Addendum No. 1

RE: Contract # C203789

Pender County (B-4929)

Bridge #16 Over The Intracoastal Waterway On NC-50/210 At Surf City

Drawing file: 400 Structure Plans - Bridges / 400_273_B4929_SMU_S137_SAP1.pdf

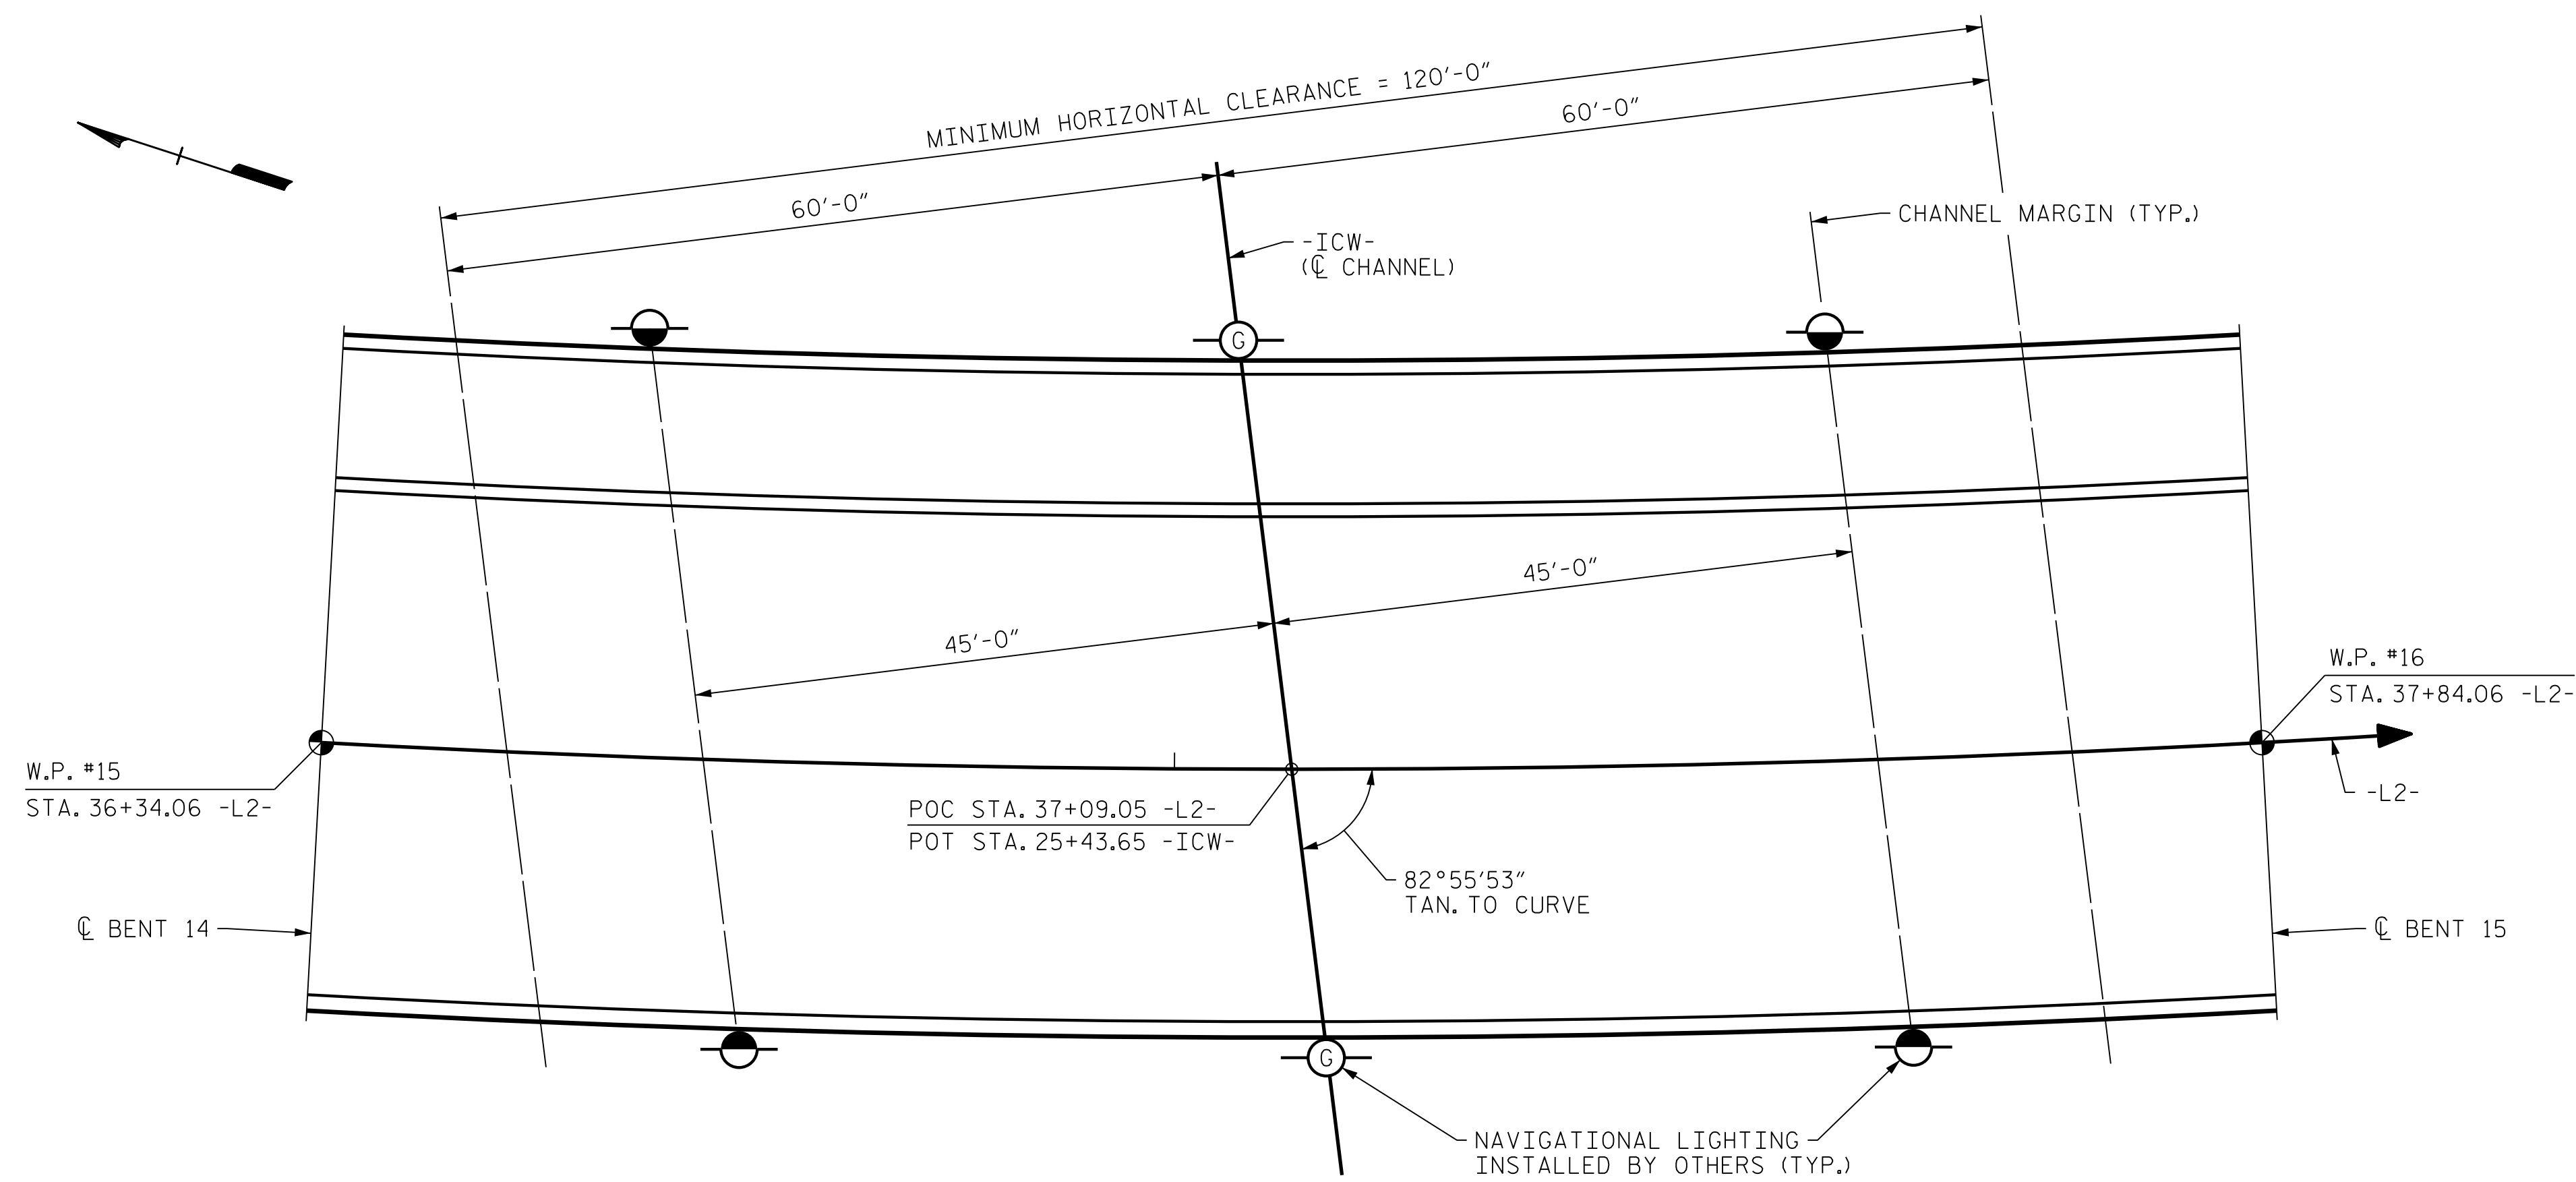
| Sheet No. | Revisions |
|-----------------|--|
| S-137 | Notes revised to clarify Navigational Lighting Requirements. |

Drawing file: 280 Utility Construction Plans / 280_039_B4929_ut_rdy4_UC10_psh.pdf

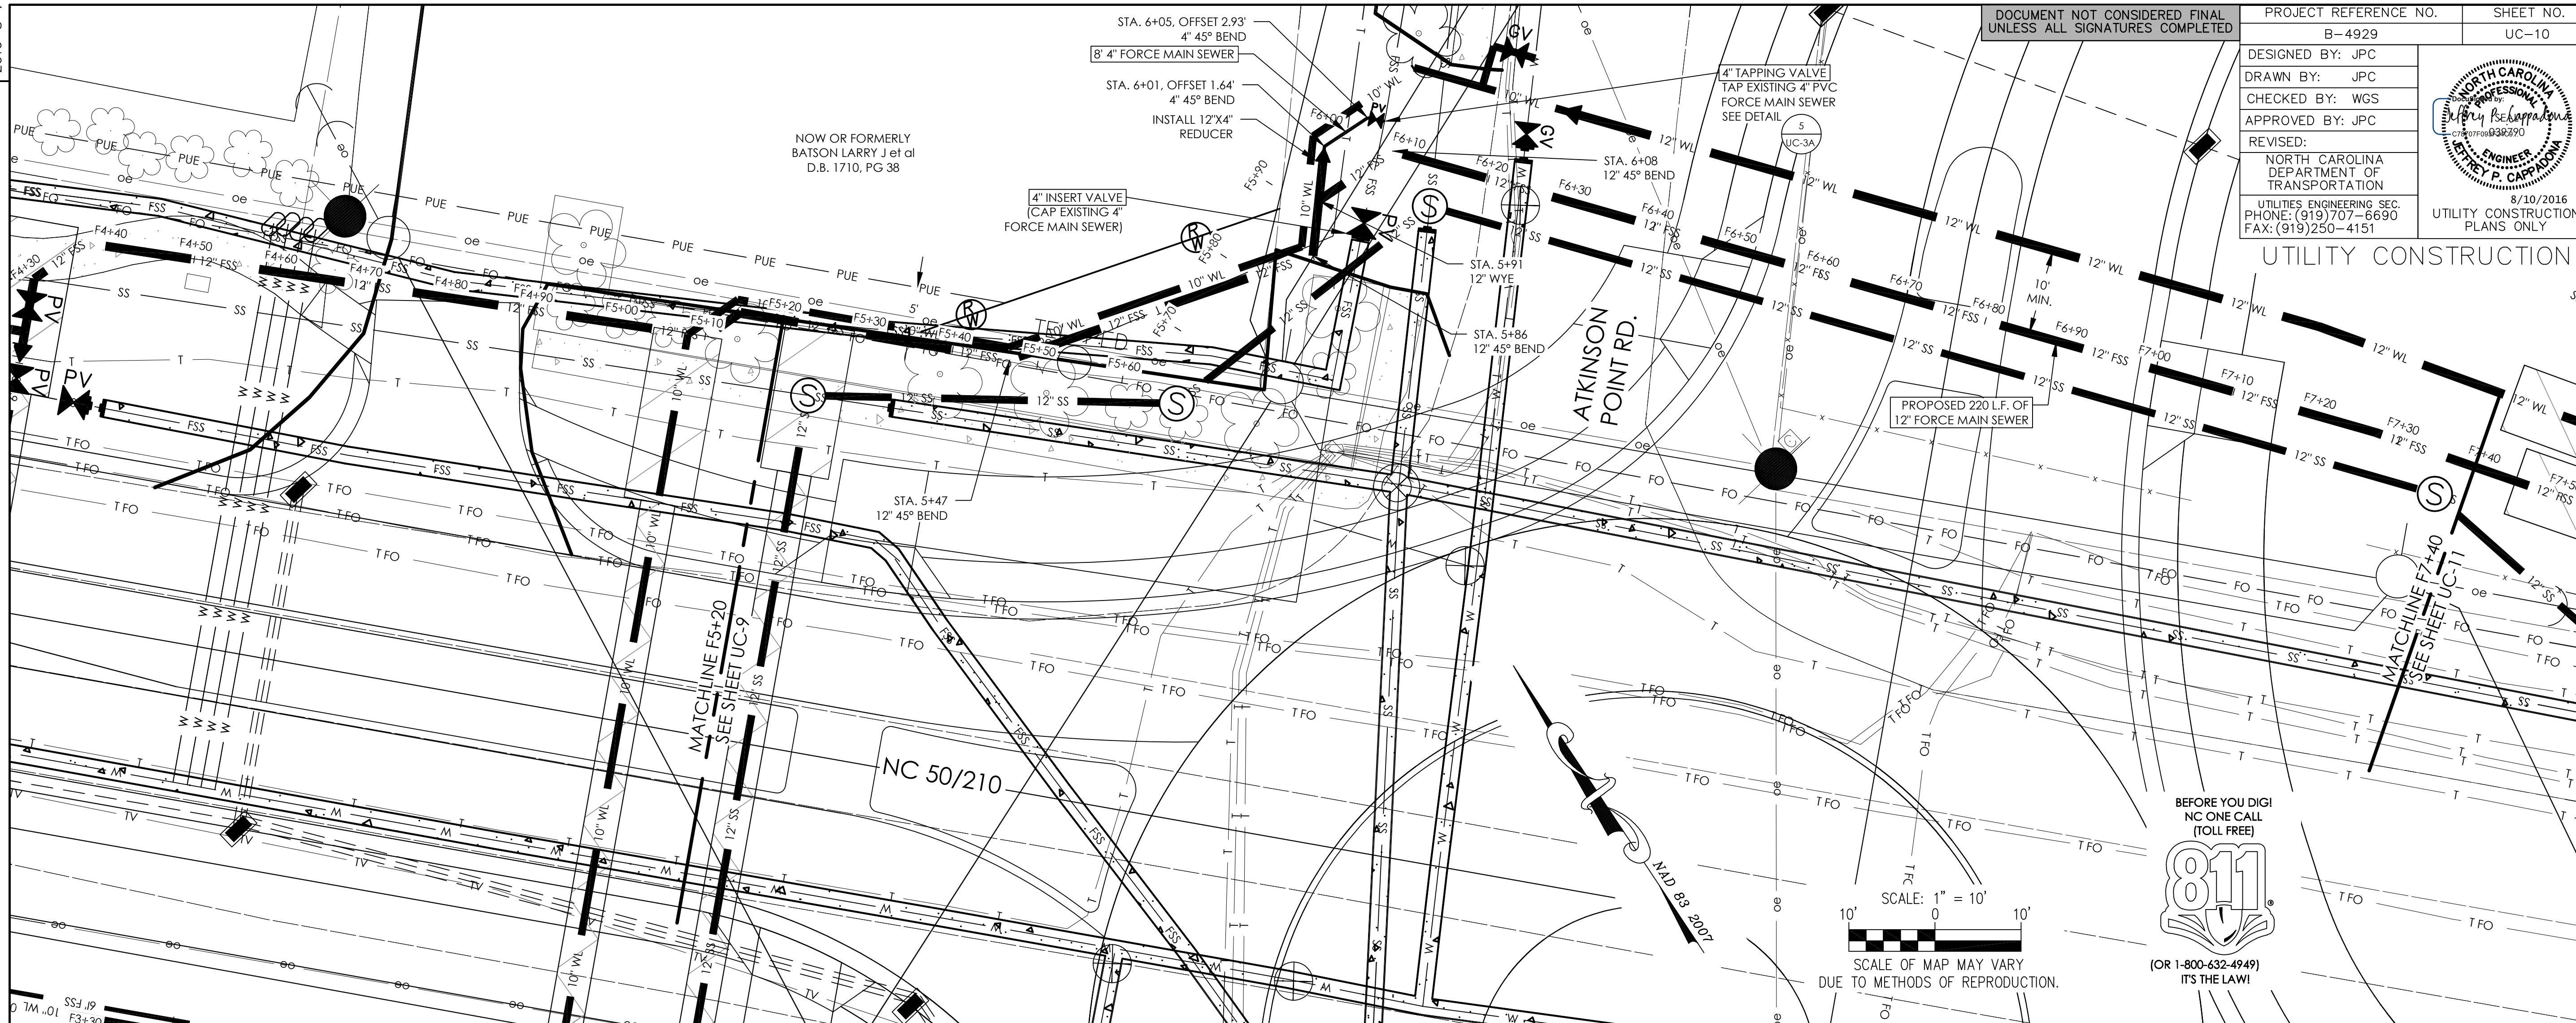
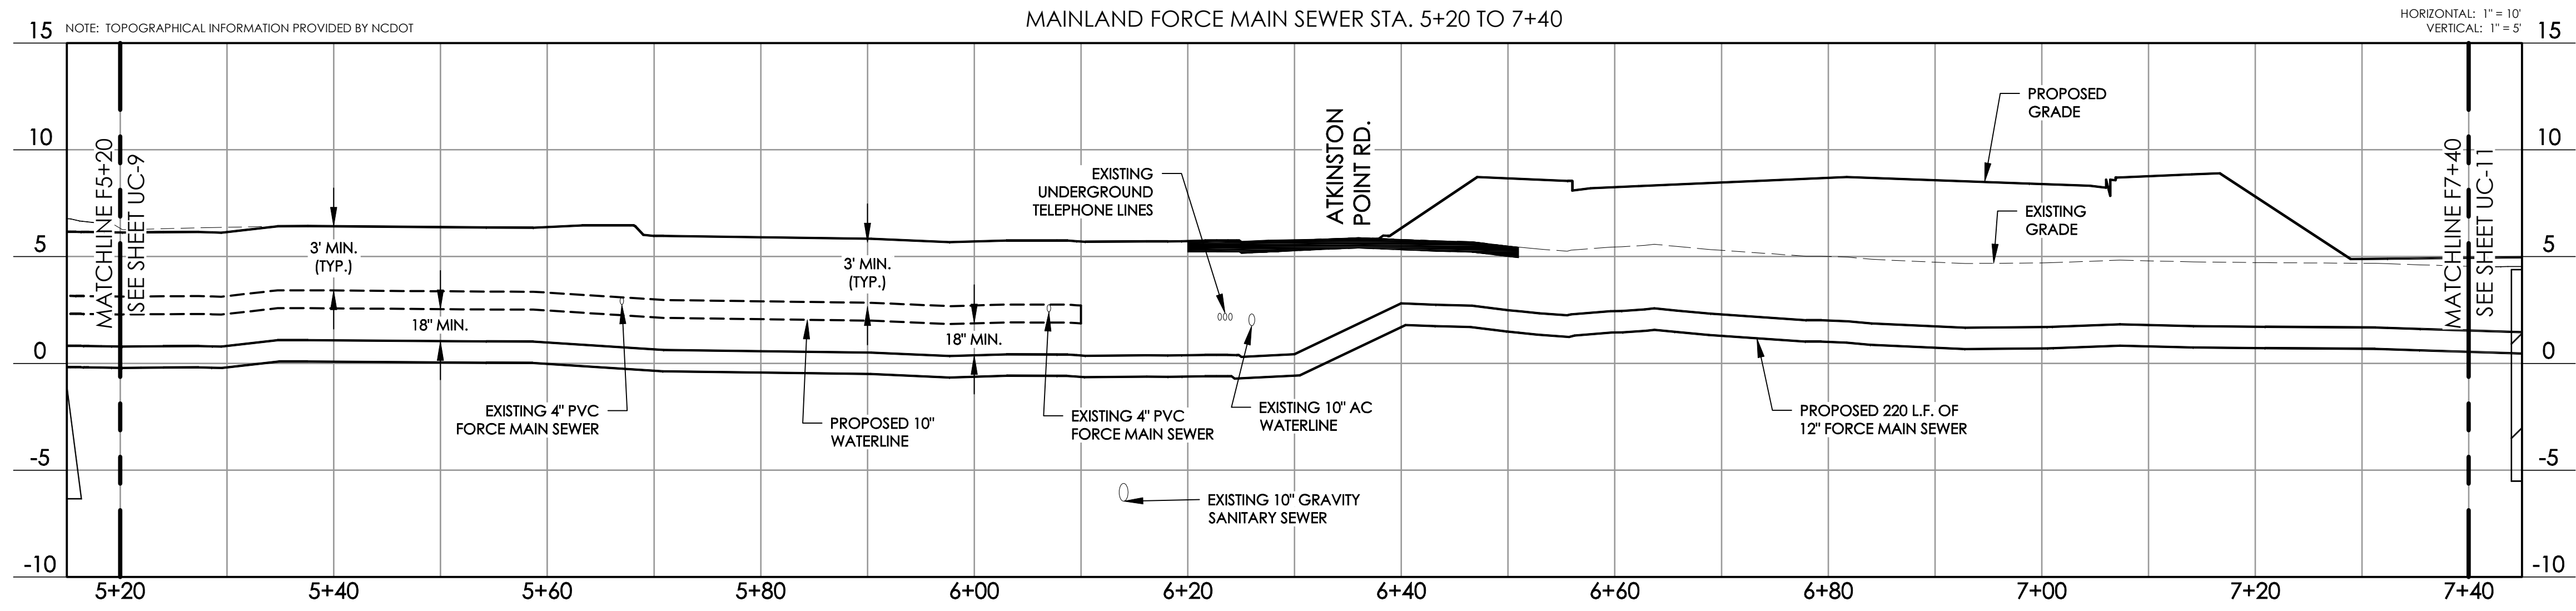
| Sheet No. | Revisions |
|-----------------|--|
| UC-10 | Correct arrow pointing to 12" Force Main Sewer. Correct 4" bends. Change 12" bend to wye. Add 4" pipe. Notes added, "4" Tapping Valve" and "4" Force Main Sewer" |

Drawing file: 280 Utility Construction Plans / 280_045_B4929_ut_rdy4_UC12_psh.pdf

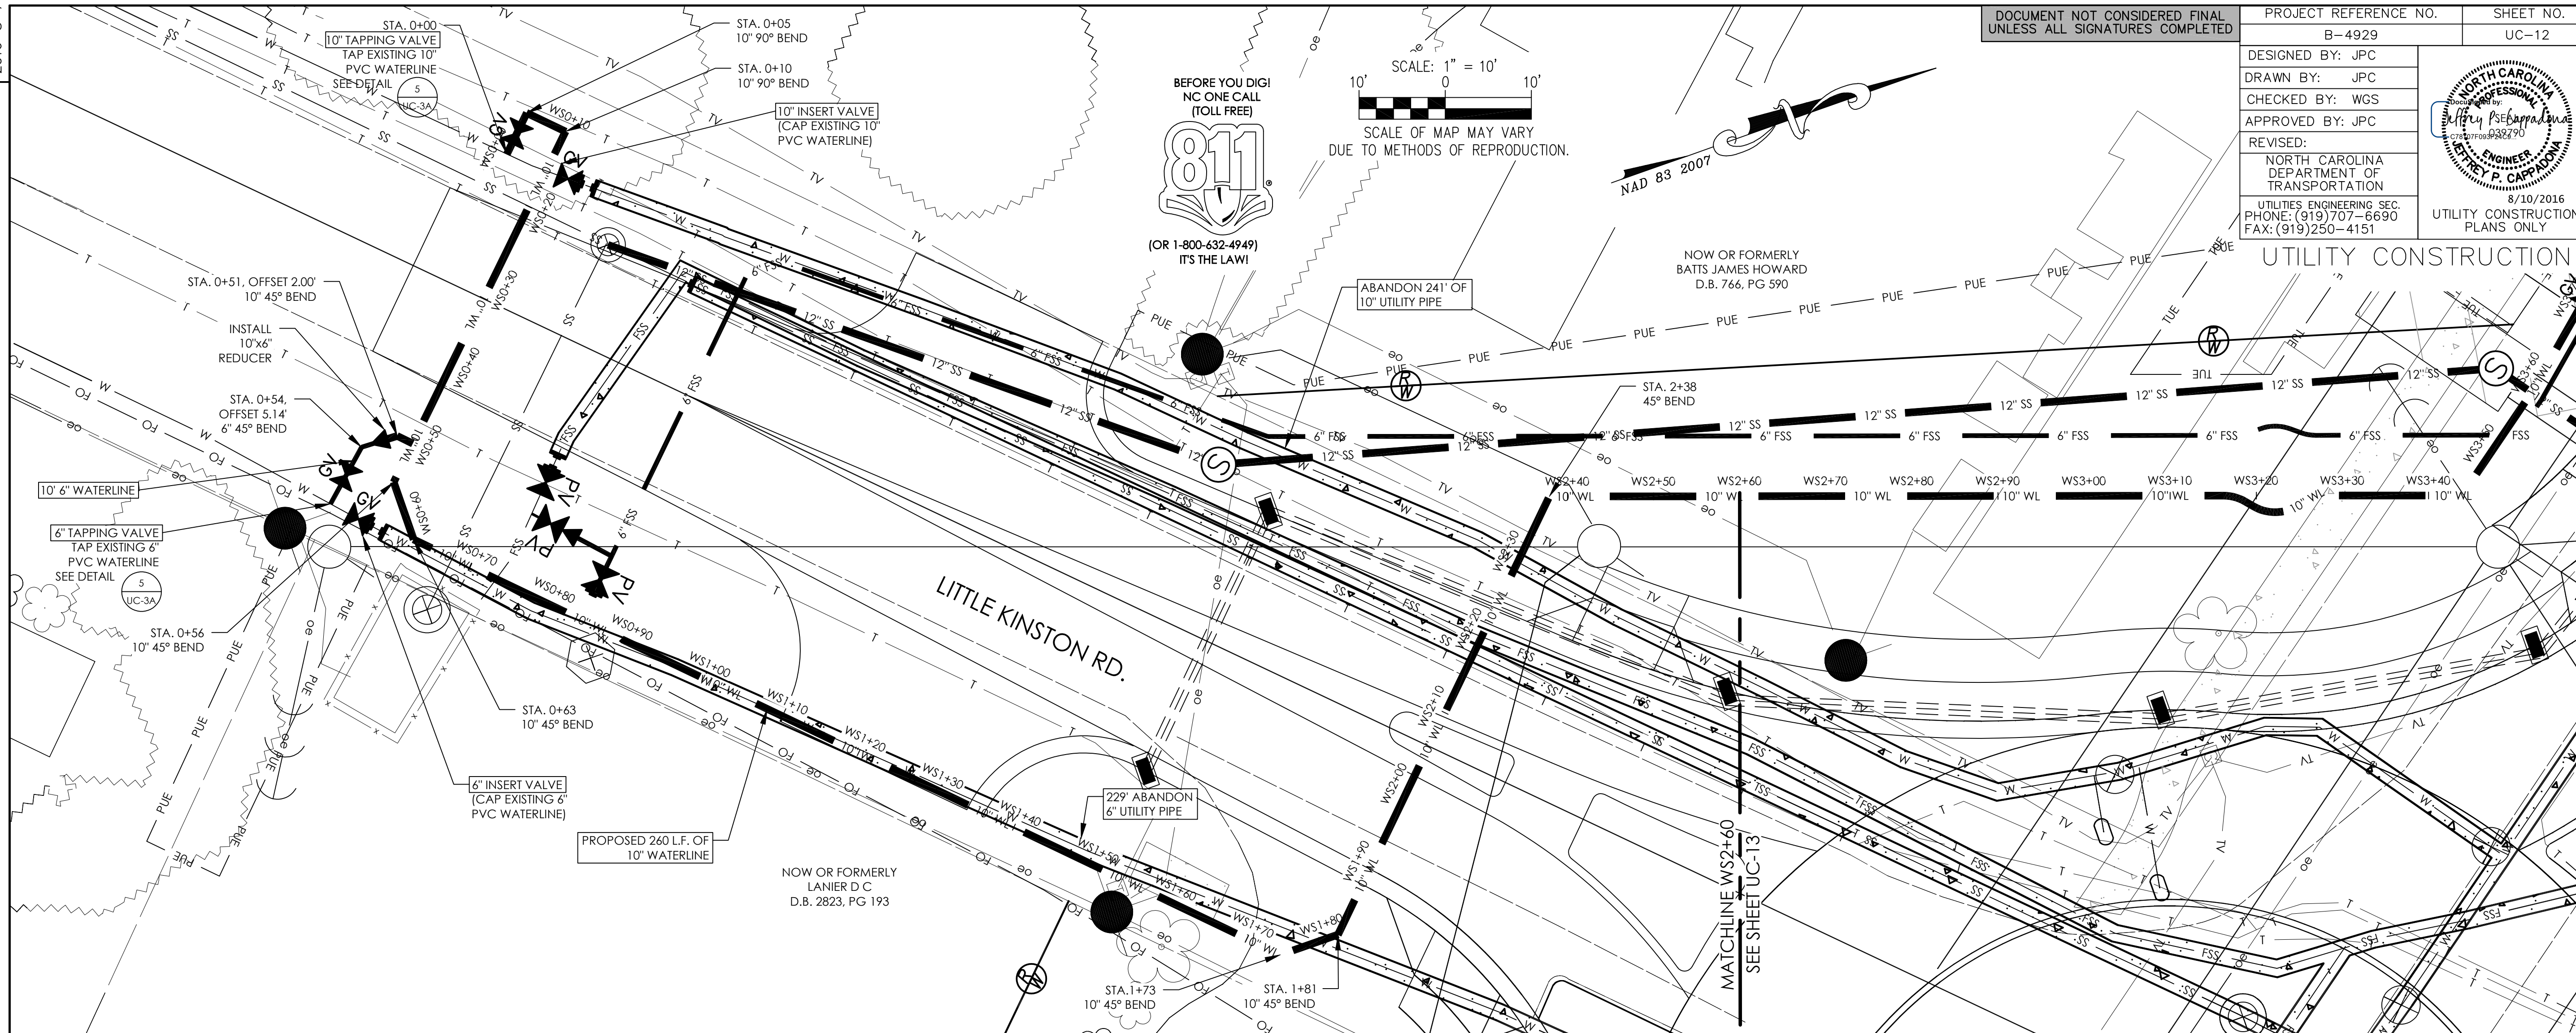
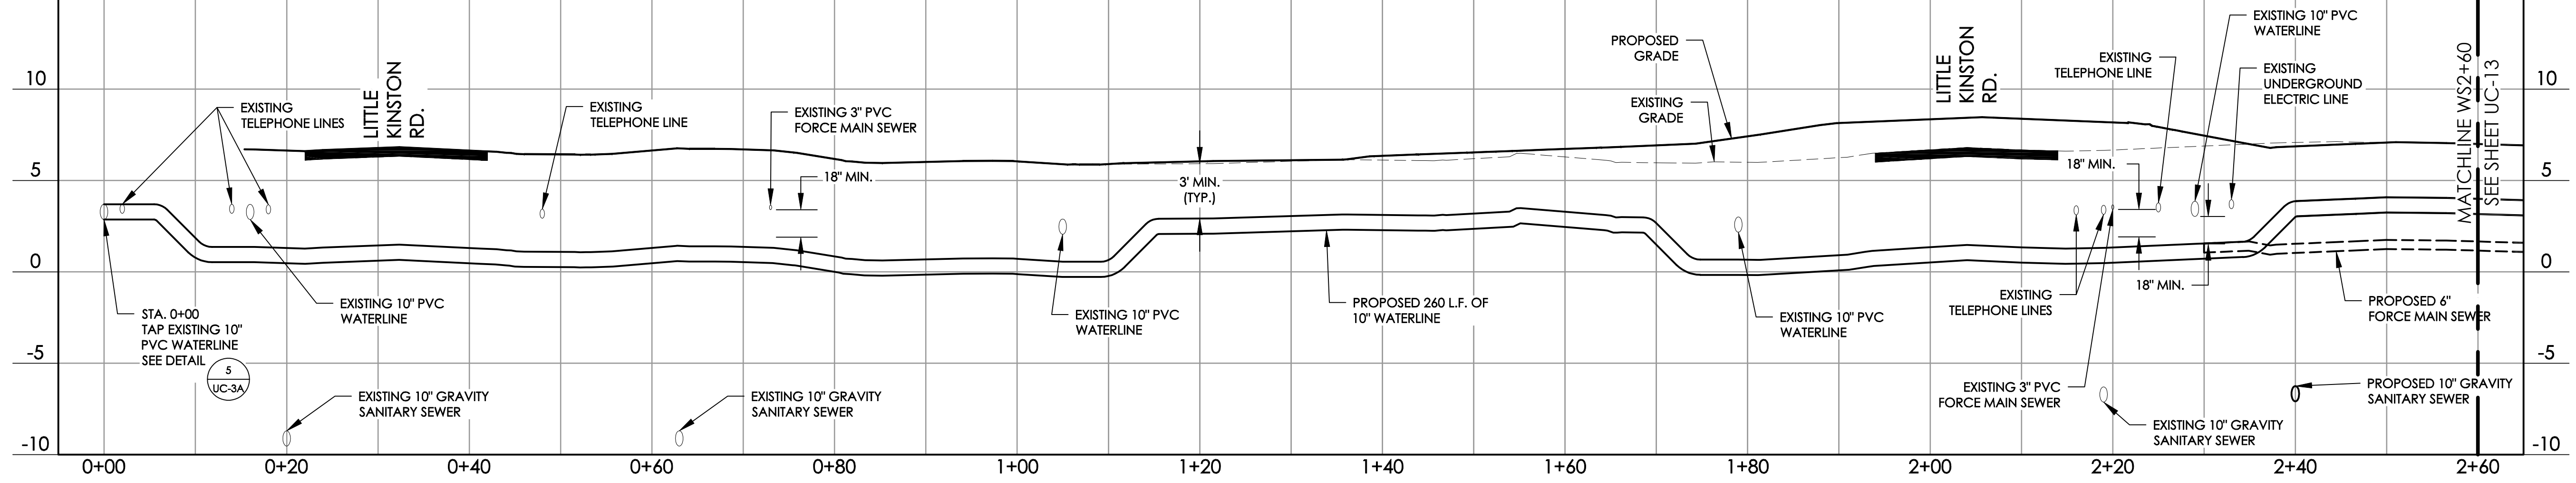
| Sheet No. | Revisions |
|-----------------|--|
| UC-12 | Correct to 6" valve. Note revised to add "6" Tapping Valve" and "10" Valve". |
